Aquind Interconnector

Deadline 5 Submission

November 2020

Figure 15.49: Indicative Landscape Mitigation Plan Option B(1) (south)

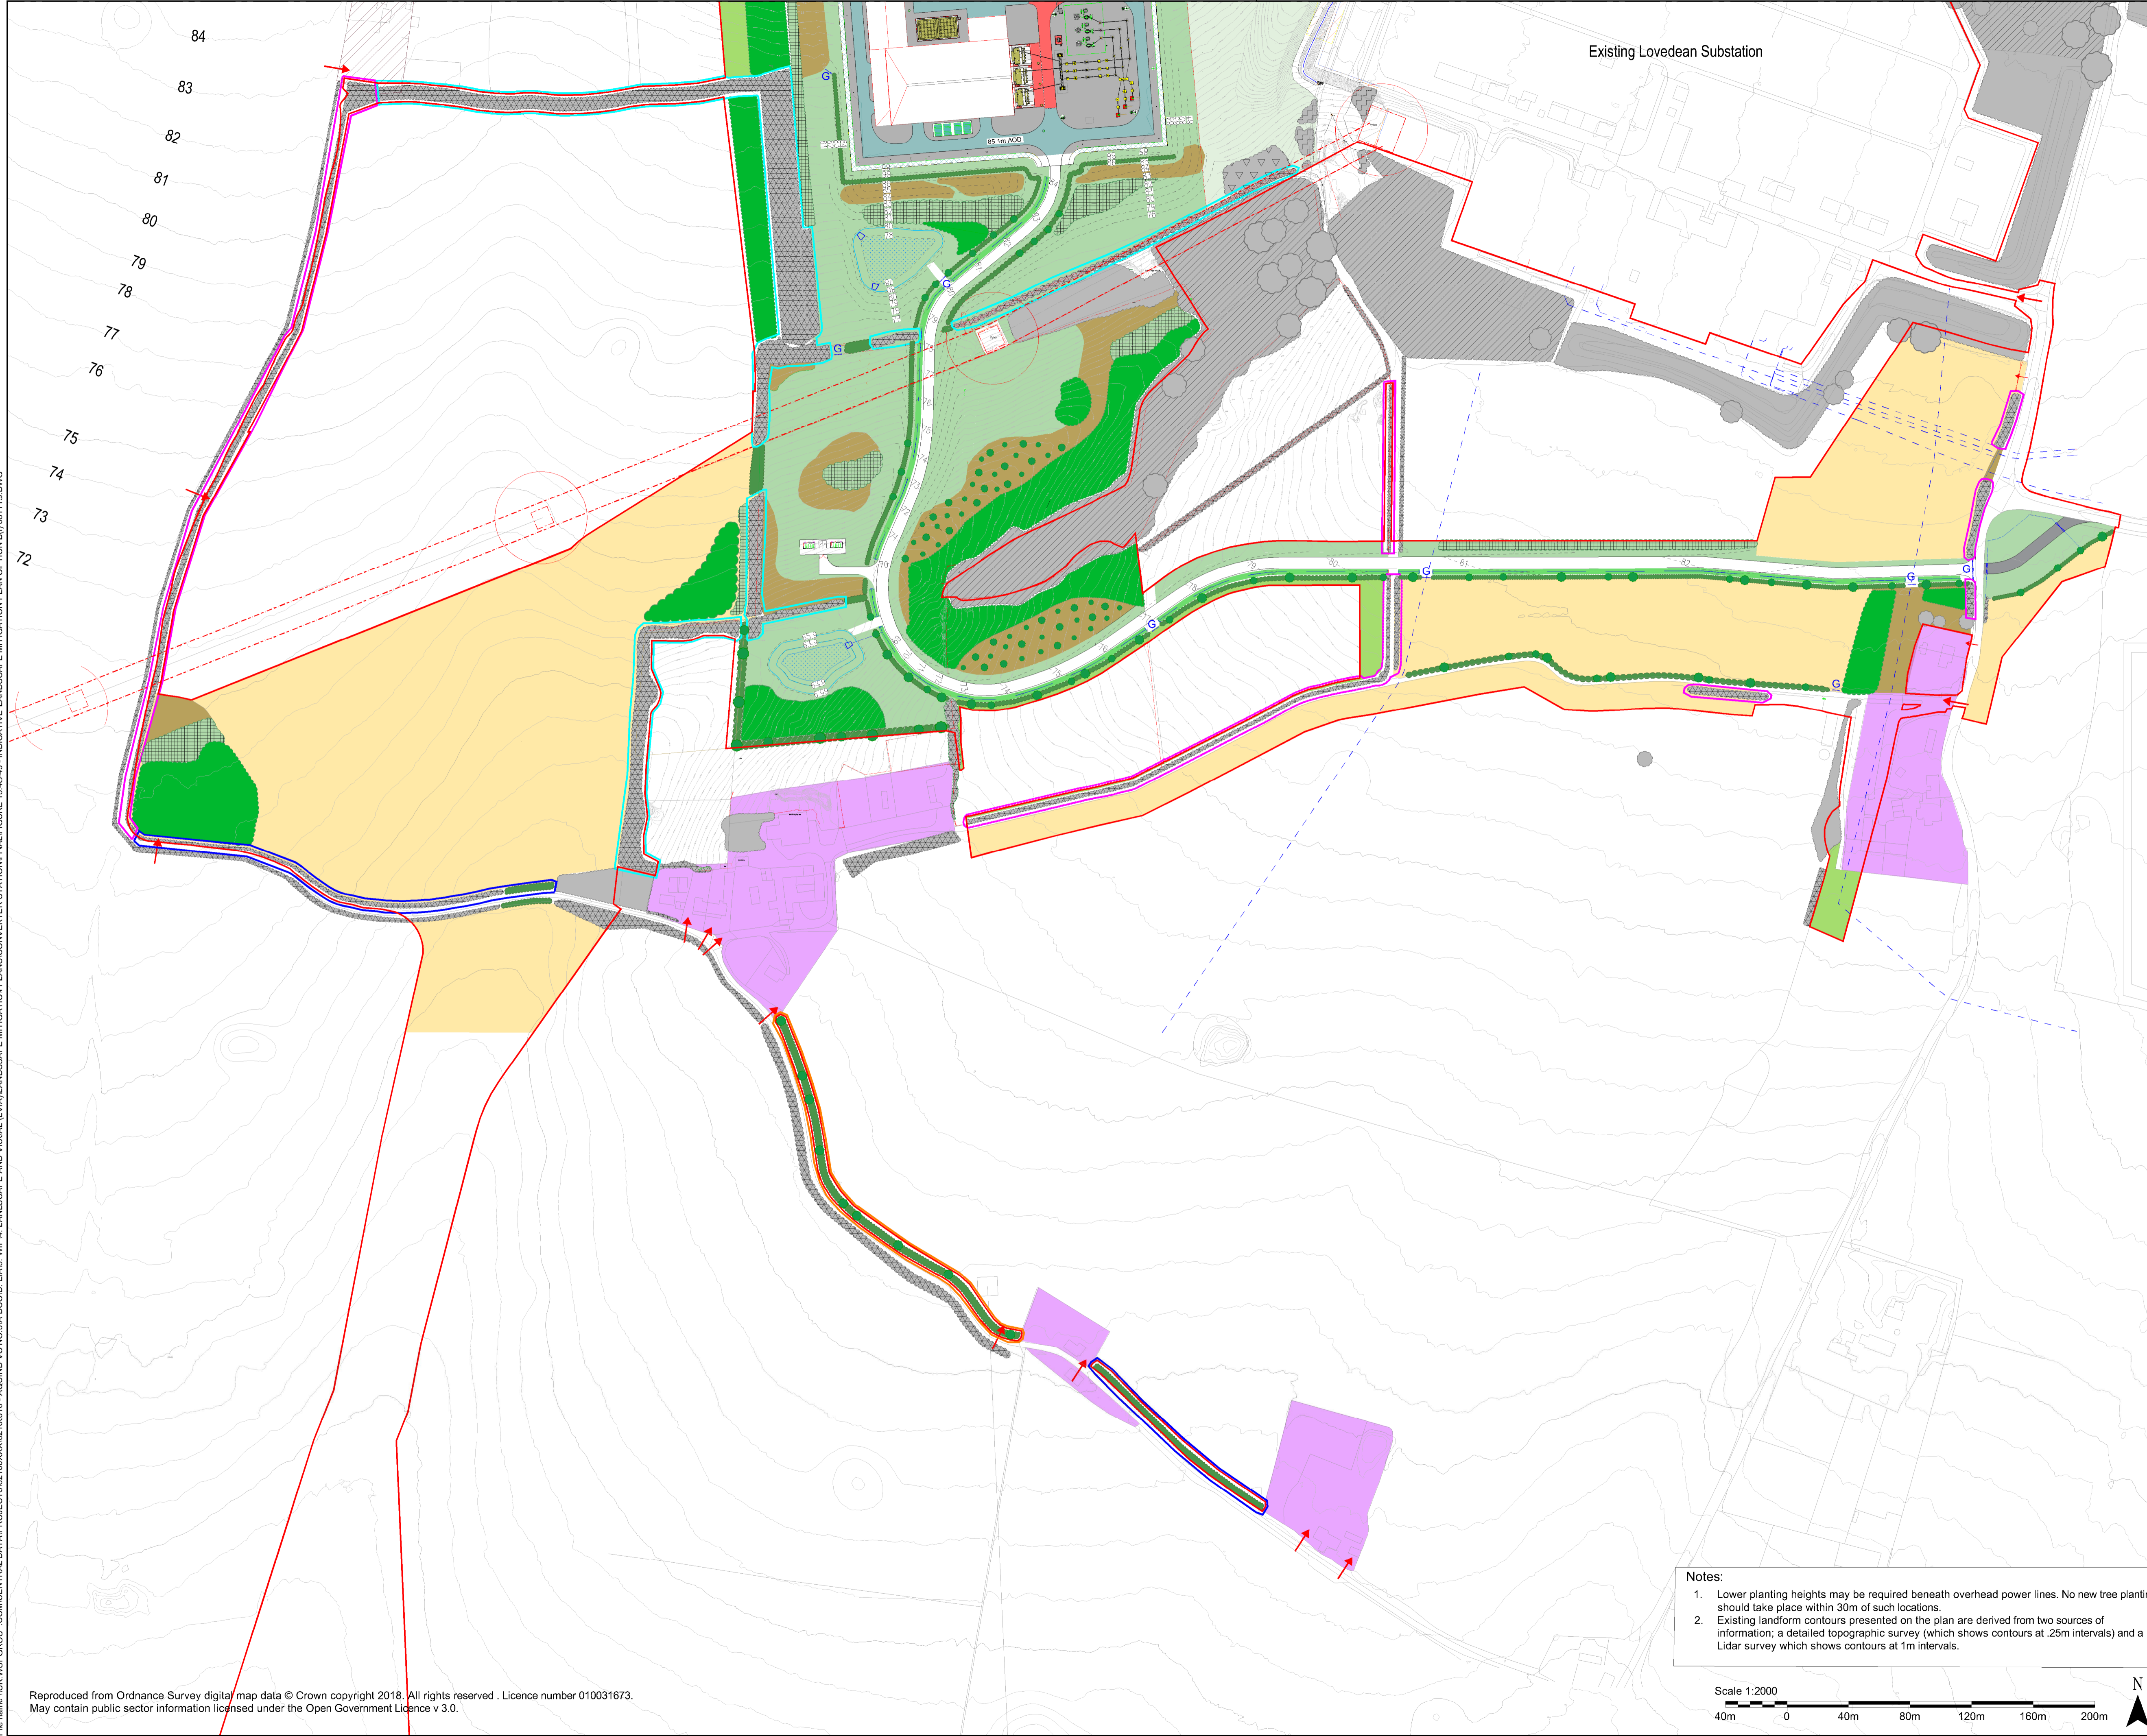
of the development the SDNPA have no further concerns in respect of this matter.
4 f) ii)	Following the Applicant's submission of further information and detail at Deadline 1, does the South Downs National Park Authority have any remaining concerns or objections in relation to the updated landscape mitigation proposals for the Converter Station? Has common ground been reached with the Applicant over this matter?	<p>The SDNPA set out its concerns with the landscape mitigation proposals in its Written Representation and its Response to the Examining Authority's First Written Questions, both submitted at deadline 1. These concerns generally still stand, subject to the further comments set out below to reflect changes made by the applicant at deadline 1.</p> <p><u>Additional woodland and hedgerow planting</u></p> <p>The Applicant has made revisions to the indicative landscape mitigation plans at deadline 1 to include additional areas of woodland planting, particularly to the south and west of the Converter Station Area and to provide a new hedgerow to the north of the Converter Station.</p> <p>The SDNPA considers it disappointing how little woodland has been added to the mitigation proposals by the applicant at deadline 1. Further, the revised proposals put forward by the applicant do nothing to address the concern we raised in our deadline 1 submissions that the treatment of the western/northern boundary is very rectilinear in contrast to surrounding field patterns.</p> <p>The applicant states in response to the SDNPA's answer to ExQ1 and question LVI.9.25 (page 2-10 of examination library reference REP2-008) that the 'new woodland planting has had to be balanced with the impact on viable agricultural land'. Yet in the statement about the hedgerow alignment (ibid, page 2-11) discusses that, with the 'need for visual screening and ecological connectivity, hedgerows were introduced and smaller fields were created which replicate those to the west of Stoneacre Copse.' The SDNPA suggest that these smaller field areas could be considered to be less viable as agricultural land and therefore, in line with the Applicant's statement, could be considered for additional woodland planting.</p> <p>The planting of additional woodland on smaller areas would also be beneficial to safeguard the local area from further loss of land to horsiculture, a land use already found extensively in the local area that is detrimental to landscape character here. In the applicant's Environmental Statement, Volume 3, Appendix 15.5 (APP-403) it states on page 6 that 'Landscape character has been eroded by: ...Diversification of land use with the subdivision of fields into numerous small paddocks edged by electric fences and set aside for horse grazing as well as areas for off road mountain biking.'</p> <p>The SDNPA suggests that the request for additional woodland would not only provide additional screening, but</p>

also could be used to stem the possible further erosion of already degraded landscape character partly due to existing subdivision of fields in the surrounding area and as now proposed in this application.

The SDNPA consider that once the condition survey is undertaken there will need to be additional landscape mitigation proposals set out that address any identified future gaps. This should also specify the period of time over which the replacement planting would be carried out and explain what would happen in the future if other areas of disease develop that are not present in the original condition survey. It is expected that further revisions will be needed to the Outline Landscape and Biodiversity Strategy to address these points.

The applicant's Outline Landscape and Biodiversity Strategy, at paragraph 1.6.7.1, recognises the need for a mix of plant stock (of local provenance where practicable) including larger trees in specific locations and native 'pioneer' species to create variations in the woodland structure and mix. Further details of the applicant's approach and intent on this matter would be welcomed, not least as the planting schedule in the Environmental Statement (Appendix 15.7, reference APP-405) incorporates the smaller planting sizes that the SDNPA raised concerns about in its deadline 1 submissions.
